NSIP Reference Name / Code: Keadby Next Generation Power Station EN0110001

Natural England's Written Representations

These Written Representations are submitted in pursuance of rule 10(1) of the Infrastructure Planning (Examination Procedure) Rules 2010 ('ExPR') in relation to an application under the Planning Act 2008 for a Development Consent Order ('DCO') for **Keadby Next Generation Power Station Project** ('the Project') submitted by Keadby Next Generation Limited ('the Applicant') to the Secretary of State.

Plate 1 Works No. 1 to 7 Extracted from Sheet 1 of Works Plans (Application Document Ref. 2.3)

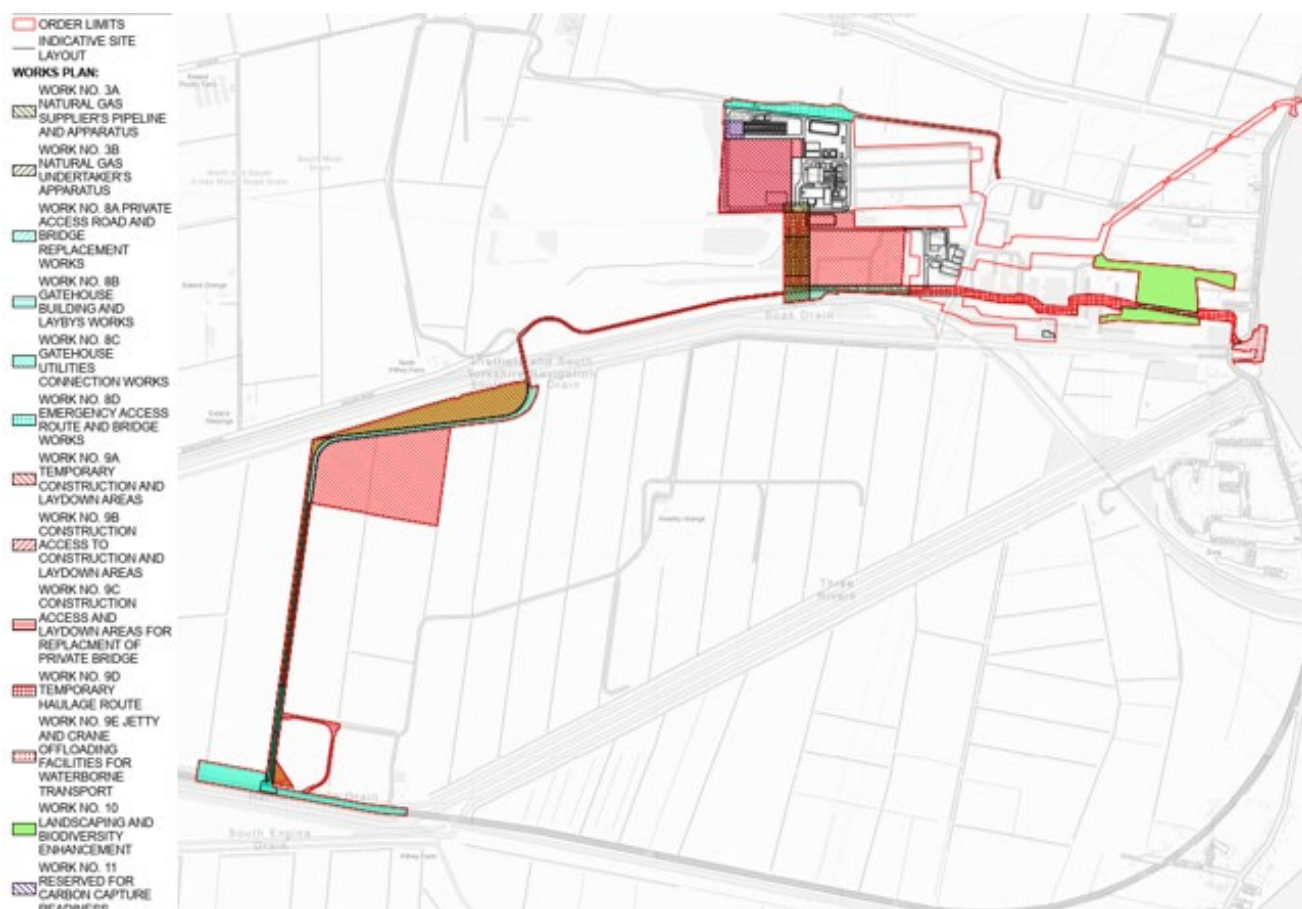
NE30	Protected species - Impacts to badgers	Plate 1 of the Outline Lighting Strategy shows that works will be completed in close proximity to Setts 9 and 10. If any lighting needs to be installed to undertake these works, the lighting design should be planned to avoid impacts to the setts and any mammal paths as much as possible.		Amber
NE31	Protected species – Impacts to bats	<p>It was noted that bat surveys were referenced from the year 2020 and that no surveys have been carried out in the last two years. Natural England’s standing advice states that surveys “[...] be carried out in the most recent, appropriate season – except if licensing policy 4 is used”</p> <p>We suggest the Applicant check to see if a mitigation licence is required using NE guidance on licencing NE wildlife licences. Applicants can also make use of Natural England’s (NE) charged service Pre Submission Screening Service for a review of a draft wildlife licence application. NE then reviews a full draft licence application to issue a Letter of No Impediment (LONI) which explains that based on the information reviewed to date, that it sees no impediment to a licence being granted in the future should the DCO be issued. This is done to give the Planning Inspectorate confidence to make a recommendation to the relevant Secretary of State in granting a DCO. See Advice Note Eleven, Annex C – Natural England and the Planning Inspectorate National Infrastructure Planning for details of the LONI process.</p> <p>The ES should assess the impact of all phases of the proposal on protected species and consideration should be given to the wider context of the site, for example in terms</p>		Grey
